**Consultation Response from KC,  
Highways Development Management****2025/92755 Millys Mini Market, 29, Ravenshouse Road, Scout Hill, Dewsbury, WF13 3QP****Erection of single storey side extension****Date Responded: 02/03/2026****Responding Officer: CNB****Responding Ref: K14-8NW/6**

Rev	Revision	Date
JOB PROPOSED SINGLE STOREY SIDE EXTENSION		
ADDRESS MILLYS MINI MARKER 29 RAVENSHOUSE ROAD DEWSBURY WF13 3QP		
Mr IRSLAN ISHTIAQ		
DATE	SCALE	SHEET
30.09.25	1:100	3@A3

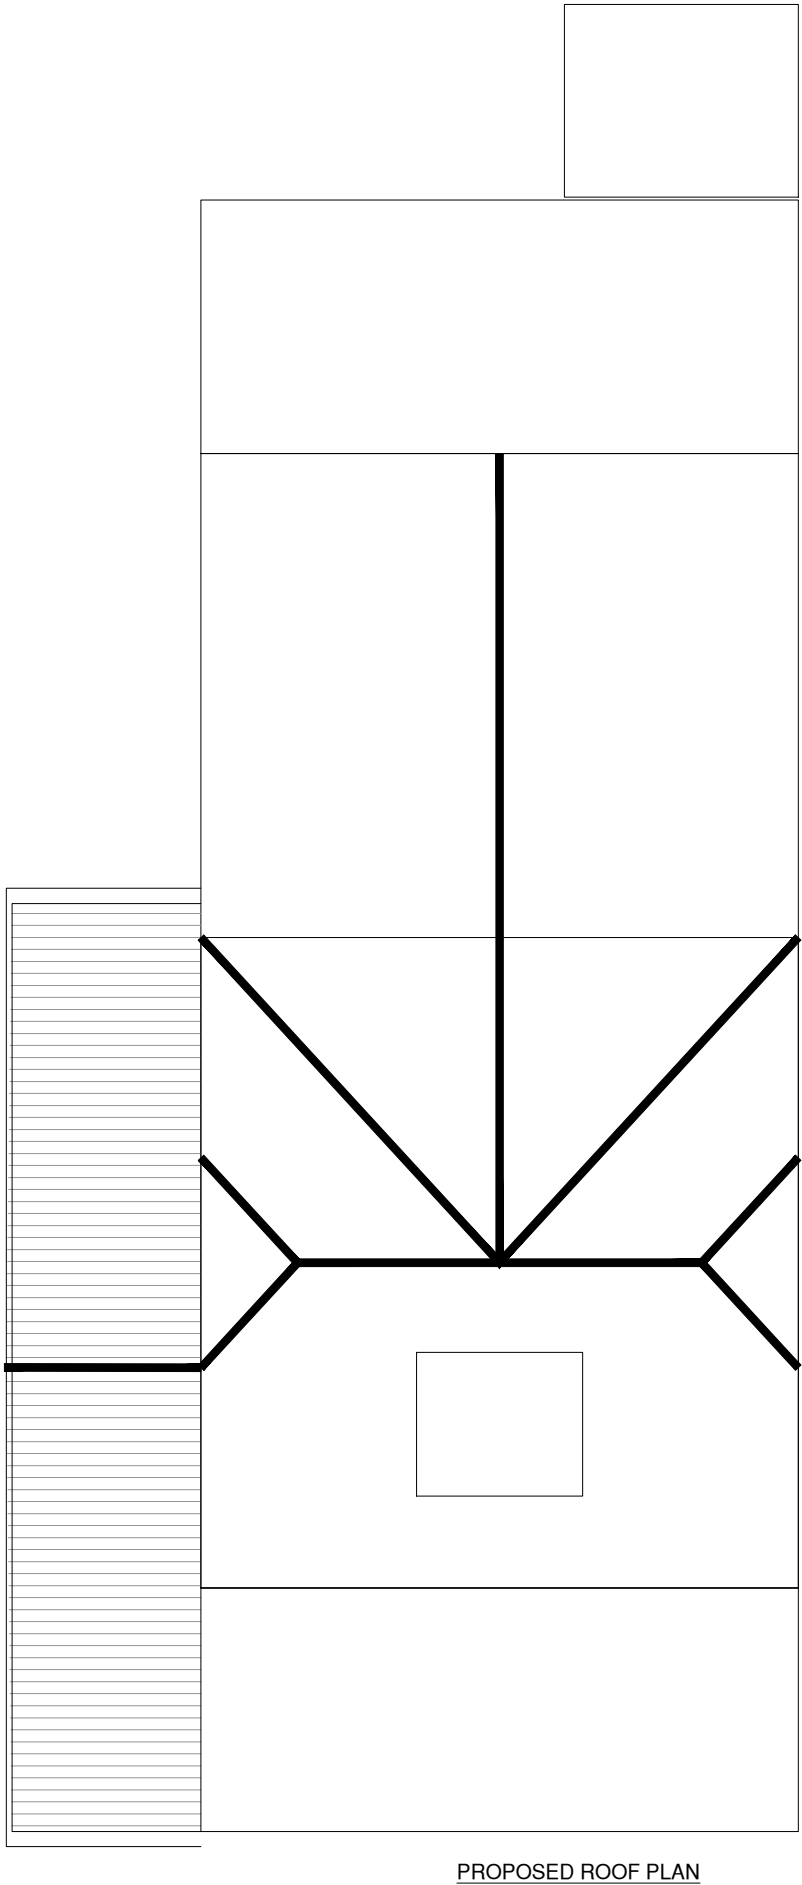
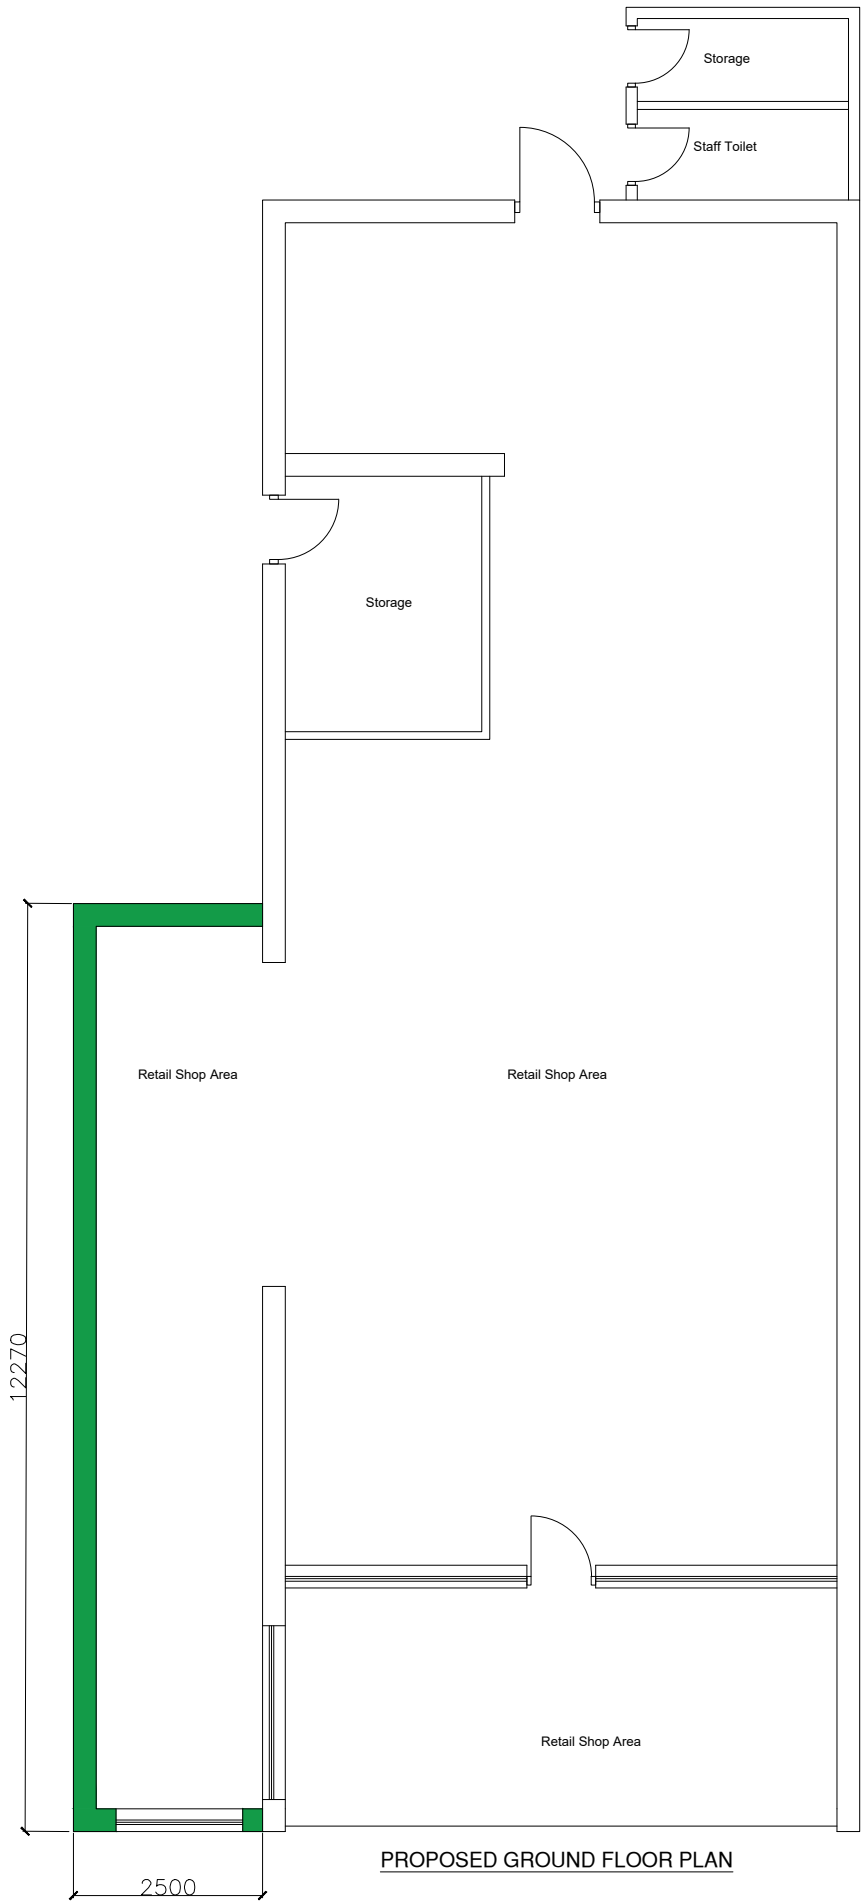
The proposals are for the erection of a single-story side extension on the side driveway of the building, and this would remove all off-street parking at the site.

If the side extension was to be set back suitably far to allow at least a single vehicle to park on the driveway, we may be able to re-assess the proposals more favourably, but we are unable to support the application as submitted with the removal of all off-street parking and wish to object.

PROPOSED SITE PLAN

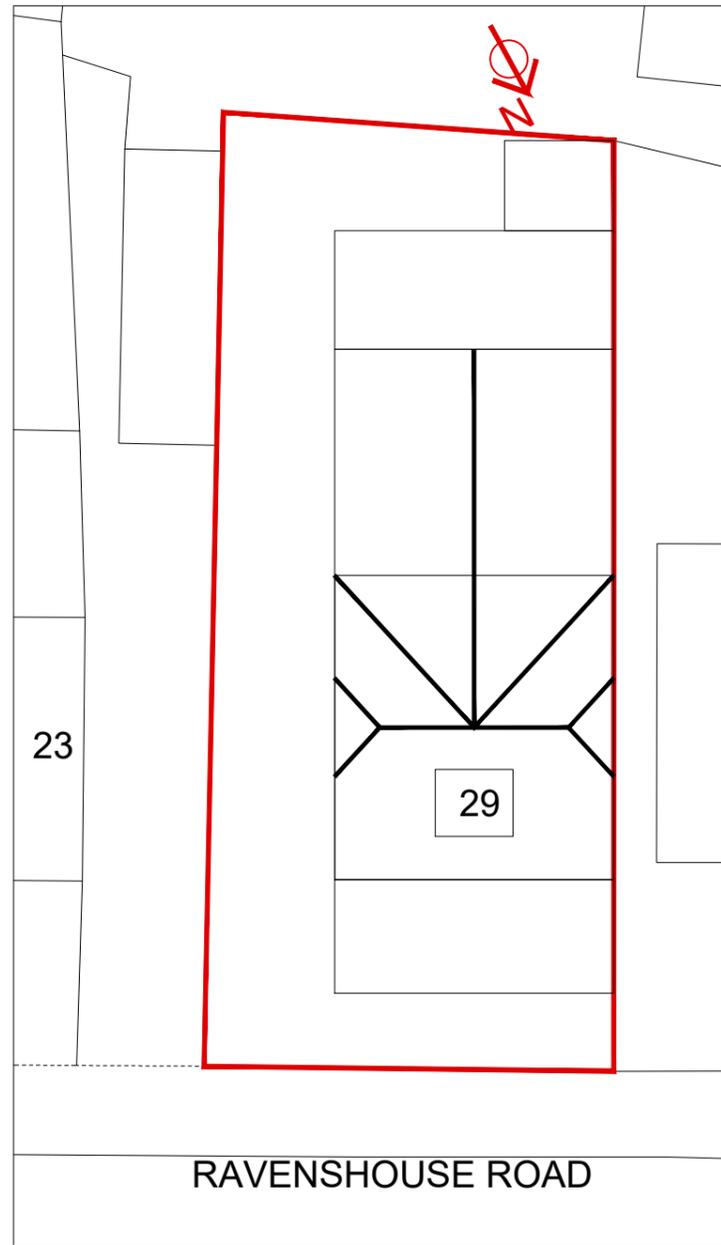
The access to the side driveway parking area is across a dropped kerb crossing and if the proposals go ahead and the driveway parking is removed, we will need to see the kerb reinstated outside of the driveway. This will need to be carried out under a s184 agreement.
